Preliminary Acceptance Punchlist
El Paso County – Department of Public Works - Stormwater Section

Project Name:	Bent Grass Commercial East F3
EDARP Filing Number(s):	CON2223
ESQCP Number:	ESQ2330
Attendees:	DPW SW: Dylan Finley, Ben Jones DPW Development Services: Brad Walters, David Parkerson Developer: Ron Waldthausen
Date of Walk-Thru:	09/07/2023
Walk-Thru Number:	1

CONCRETE FOREBAY

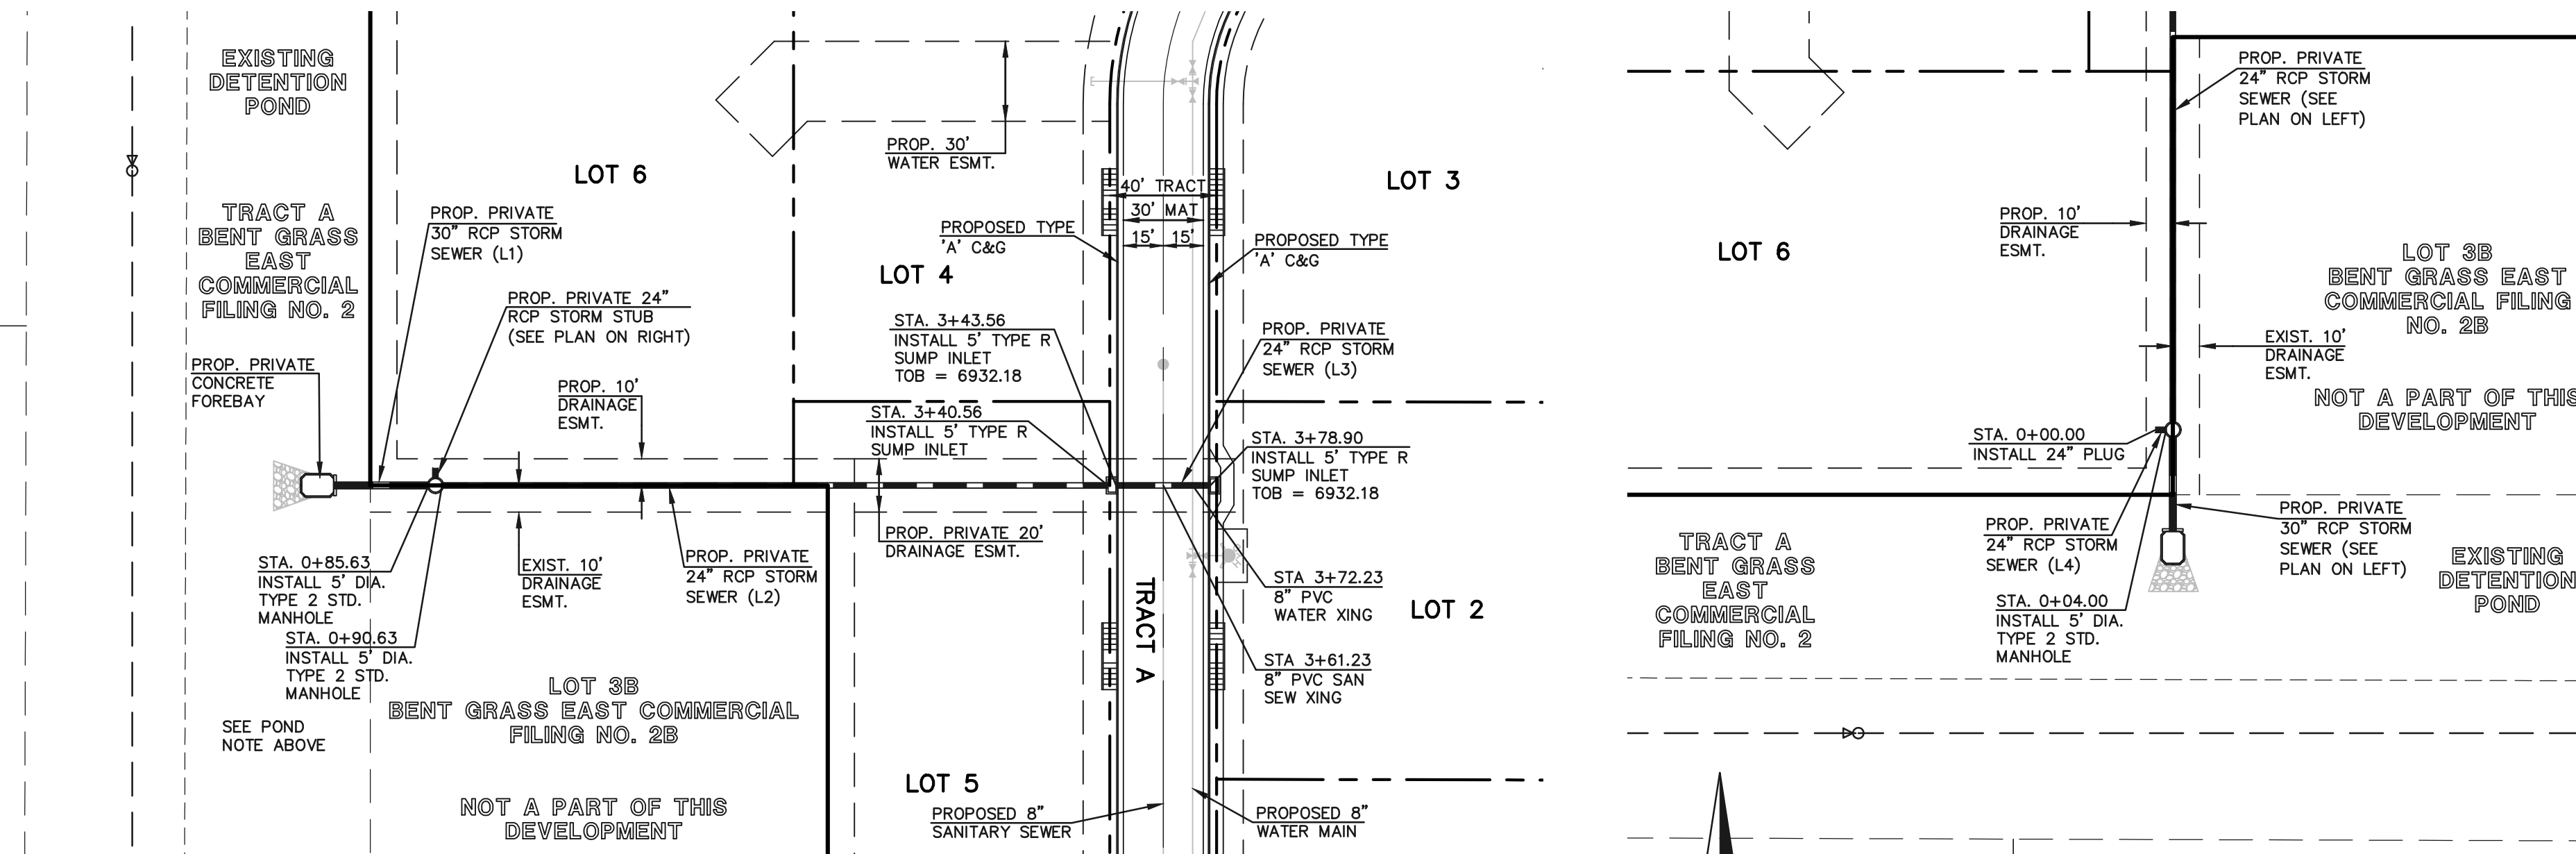
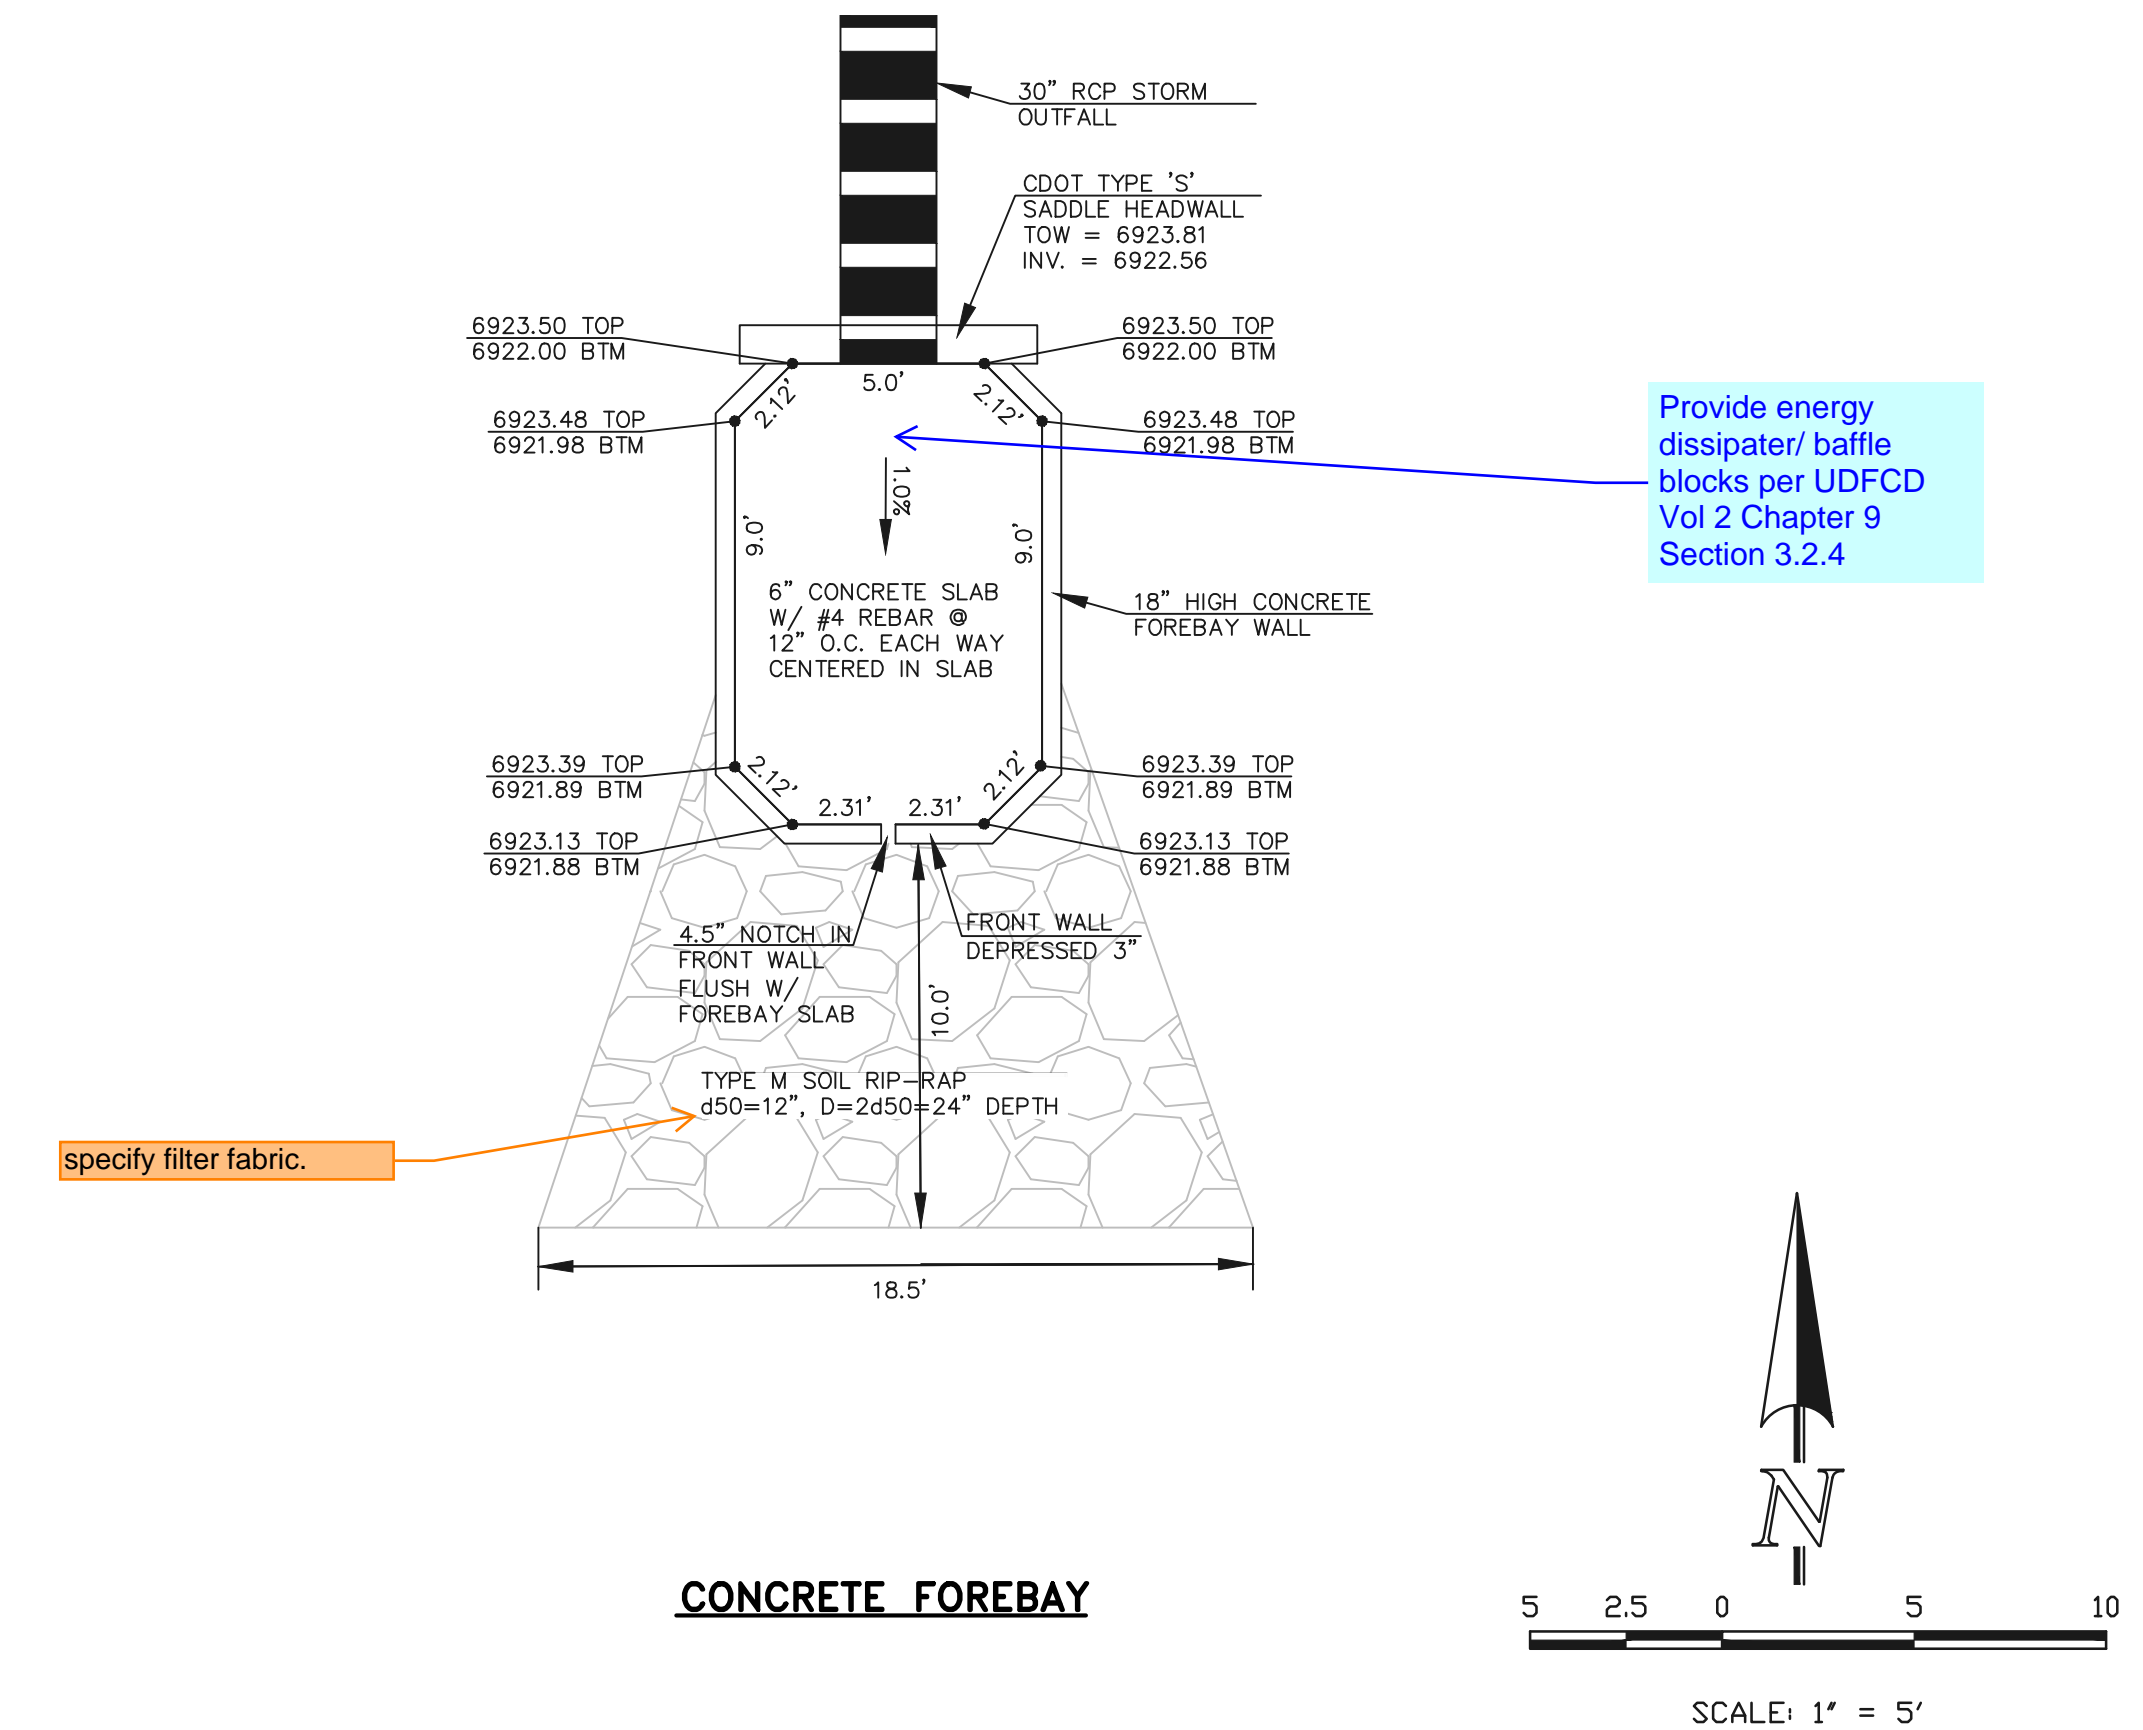
Pond [Page 7 of Construction Drawings]:

- Soil Riprap missing at forebay. Install soil riprap per spec.

<p>8036 Meridian Park Rd Peyton CO 80831 United States +38.948405 -104.609995 127° SE Sep 7, 2023 at 1:40:26 PM</p>	
<p>Photo 1: See page 7 of construction drawings. Concrete forebay missing soil rip rap.</p>	<p>Photo 2: [Caption]</p>
